**RE: Glendale Estates Unit 3
Grading and Drainage Plan
Engineer's Stamp Date 4/28/18
Hydrology File: B19D027**

RE: **Glendale Estates Unit 3**
Grading and Drainage Plan
Engineer's Stamp Date 4/28/18
Hydrology File: B19D027

**Re: Glendale Estates Unit 3 Grading & Drainage Plan
Engineer's Stamp Dated 1/29/2017
(B19D027)**

ENGINEER'S SEAL	ESTATES AT GLENDALE UNIT 3	DRAWN BY WCVJ
		DATE 1-18-17
4/28/18	GRADING AND DRAINAGE PLAN	21425-LAYOUT-1-25-18
DAVID SOULE P.E. #14522	 <i>Rio Grande Engineering</i> 1606 CENTRAL AVENUE SE SUITE 201 ALBUQUERQUE, NM 87106 (505) 872-0999	SHEET # 4
		JOB # 21425

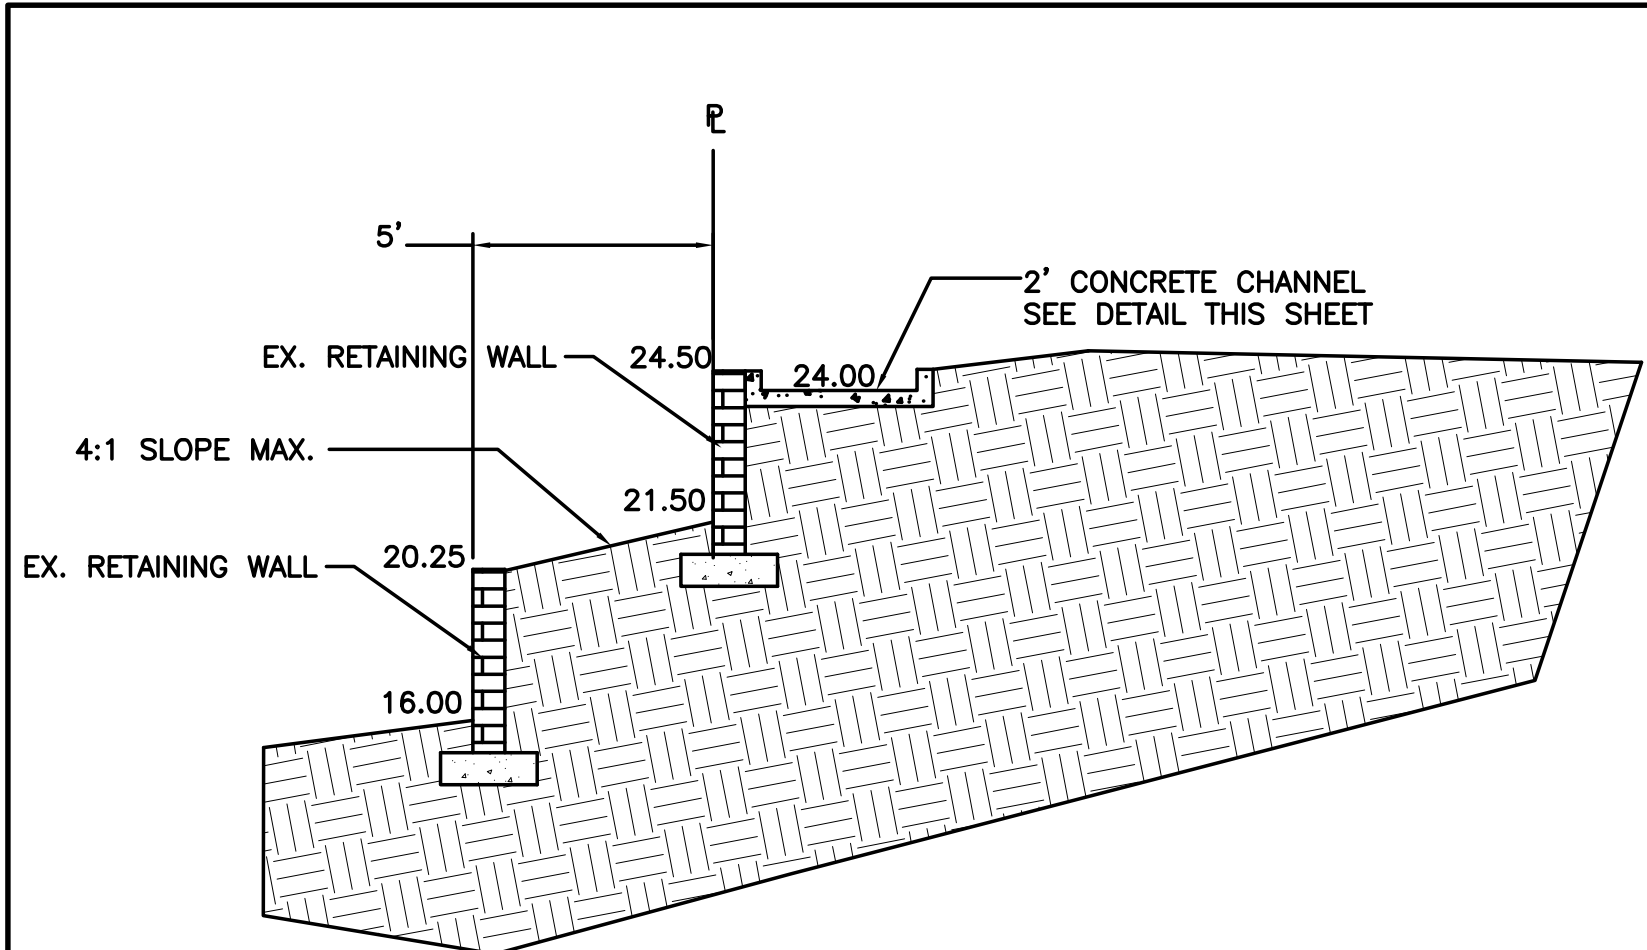
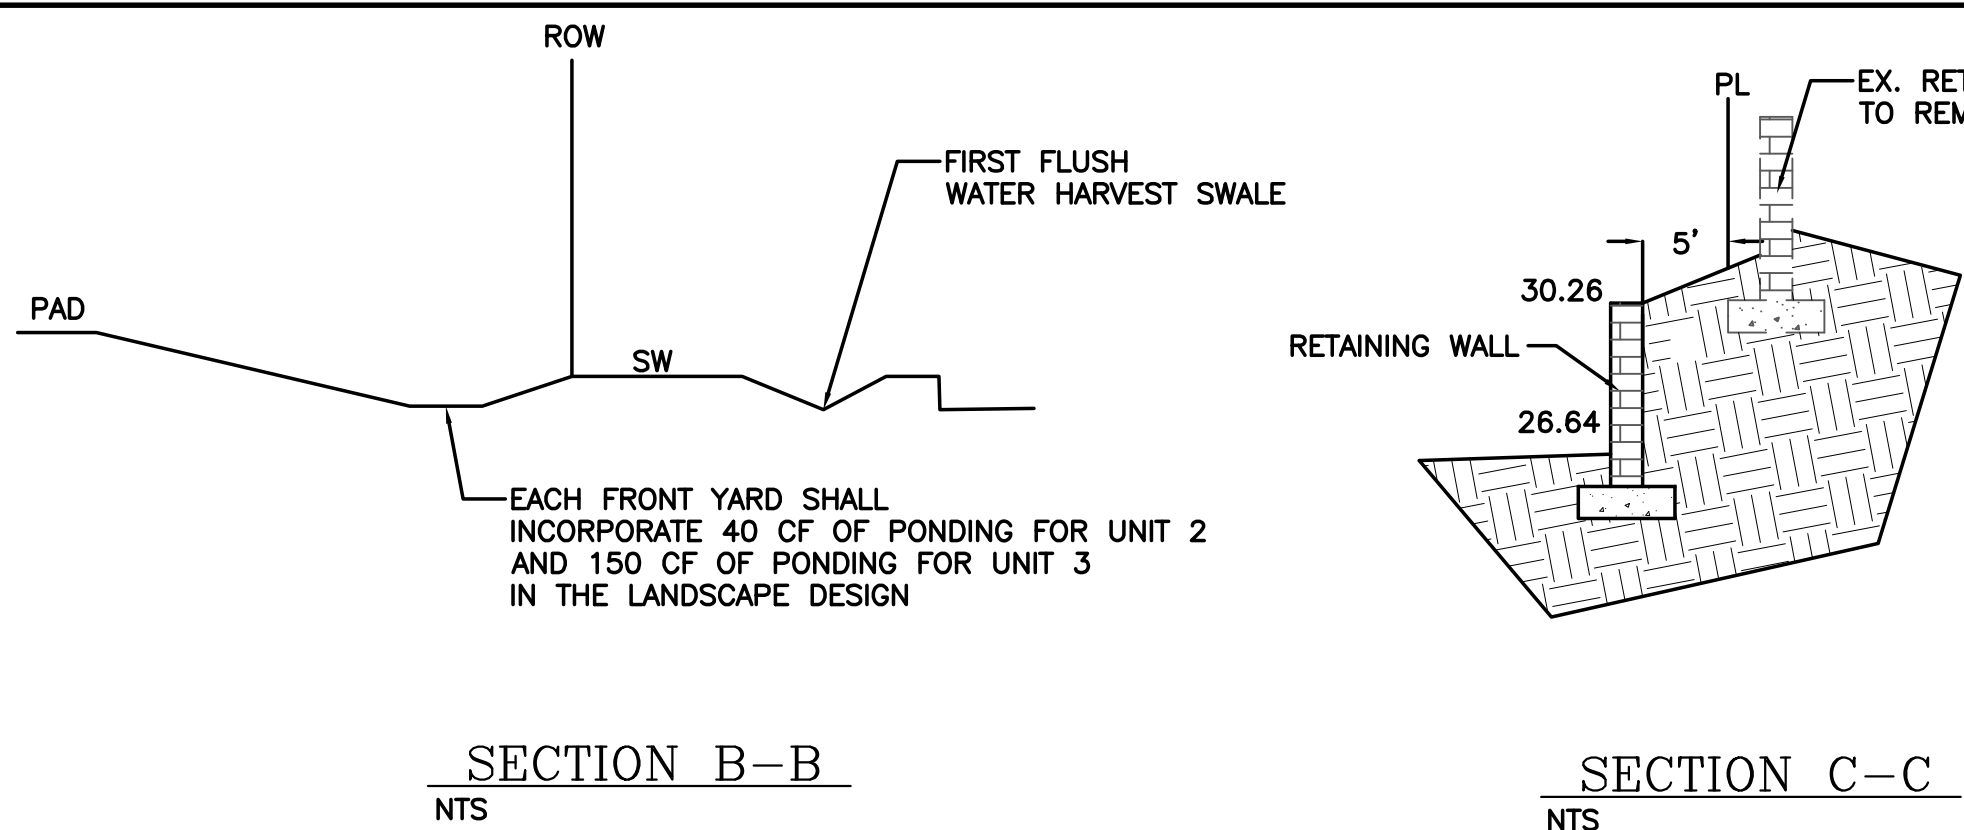
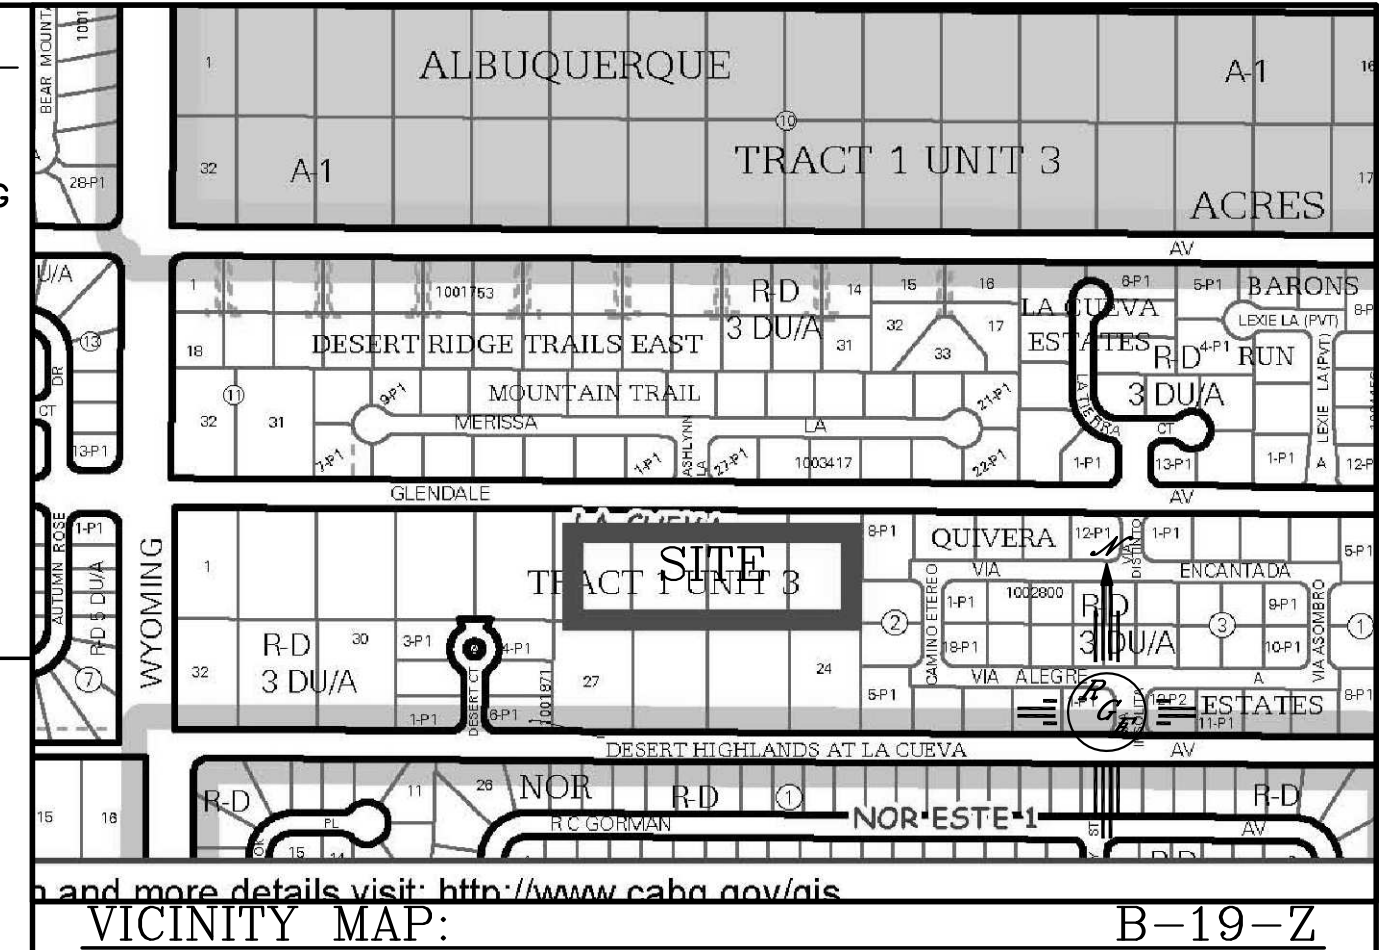
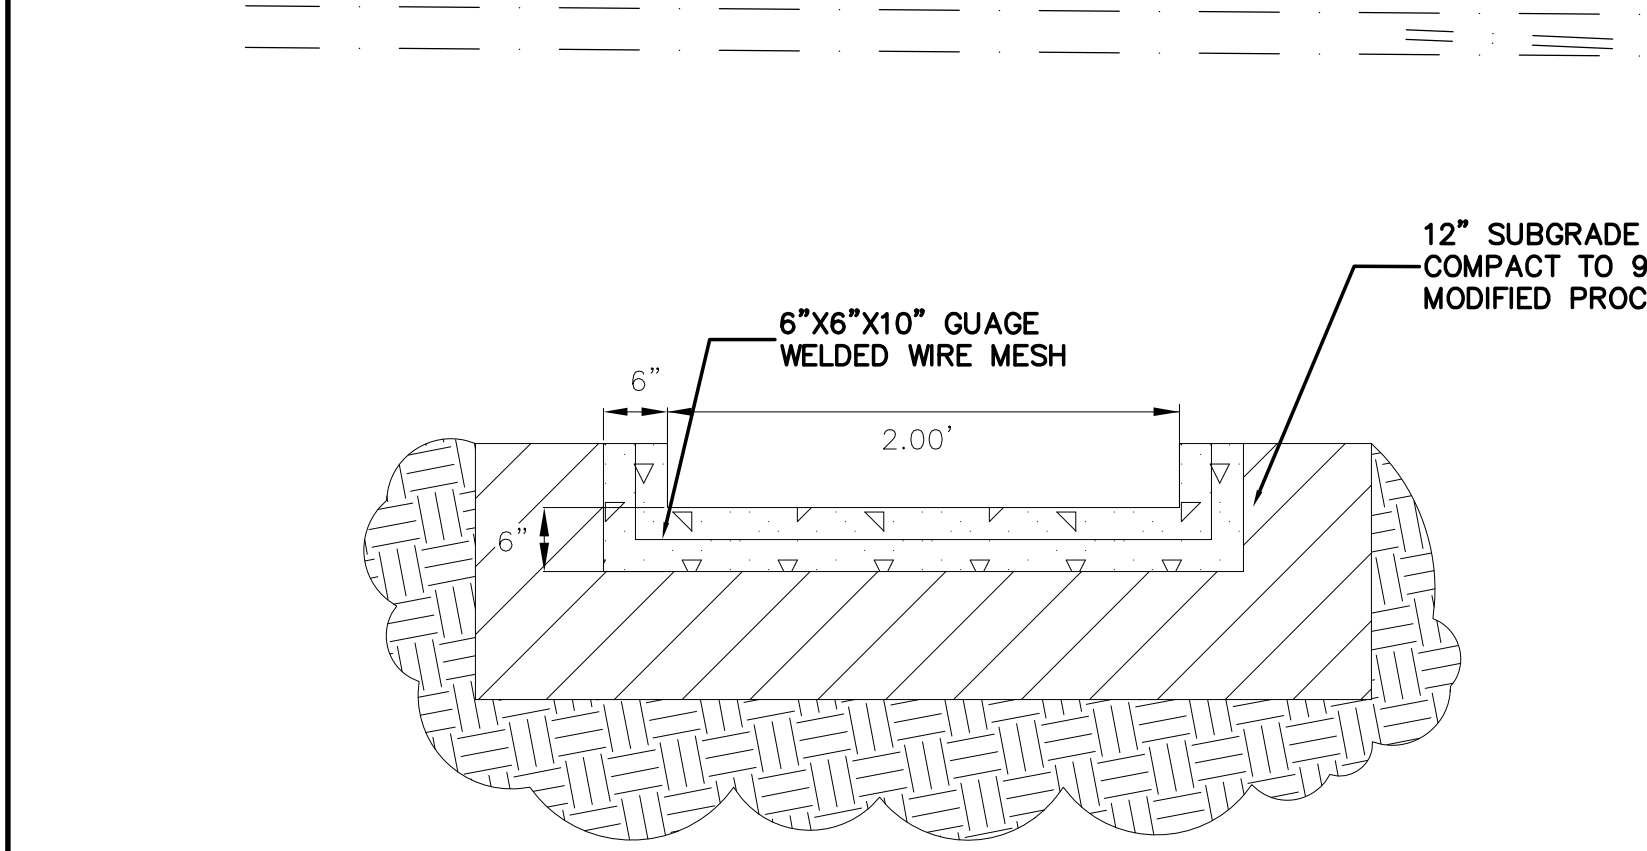
1. Provide written and signed permission from the adjoining landowner to the south for the footer encroachment onto their property.
2. Provide supporting calculations for the HGL in the new storm drain.
